From: Zac Denton
Sent: 30 November 2018 10:35
To: Planning.Responses
Subject: FW: Planning Application - Sunny Bank, Dairy Lane, Walberton

Conservation officer comment

From: Peter Davey [REDACTED]
Sent: 29 November 2018 11:14
To: Zac Denton
Subject: Planning Application - Sunny Bank, Dairy Lane, Walberton

Proposed North Elevation (side)
1:100 @ A3

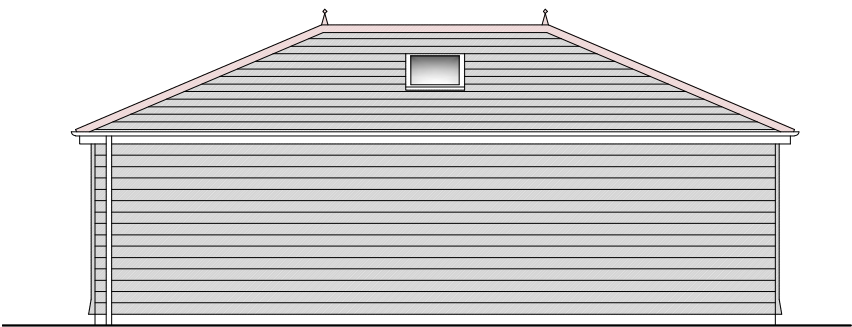
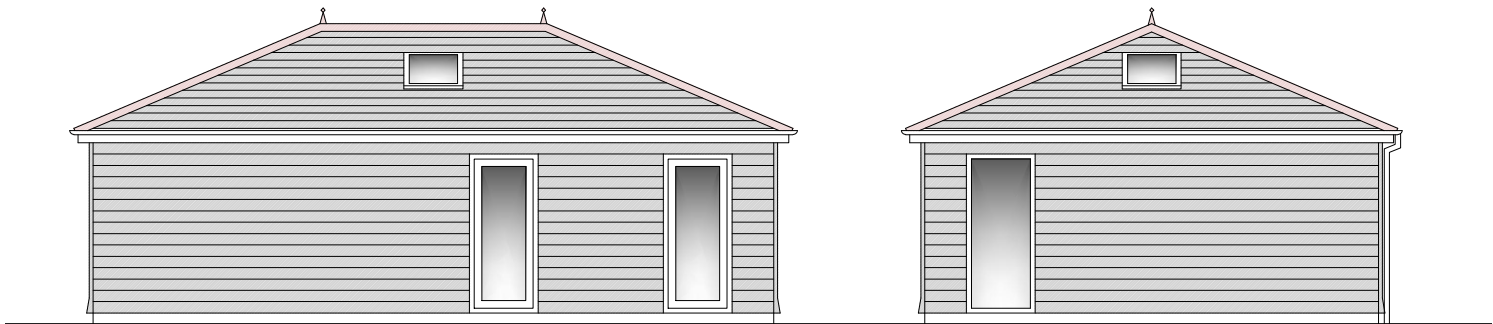
Further to our telephone conversation yesterday, I have spoken to the applicant who has agreed to include foliage screen along the northern (highway) edge of the proposed garage.

I think that a foliage screen would be acceptable -- please request details of what they propose by way of condition
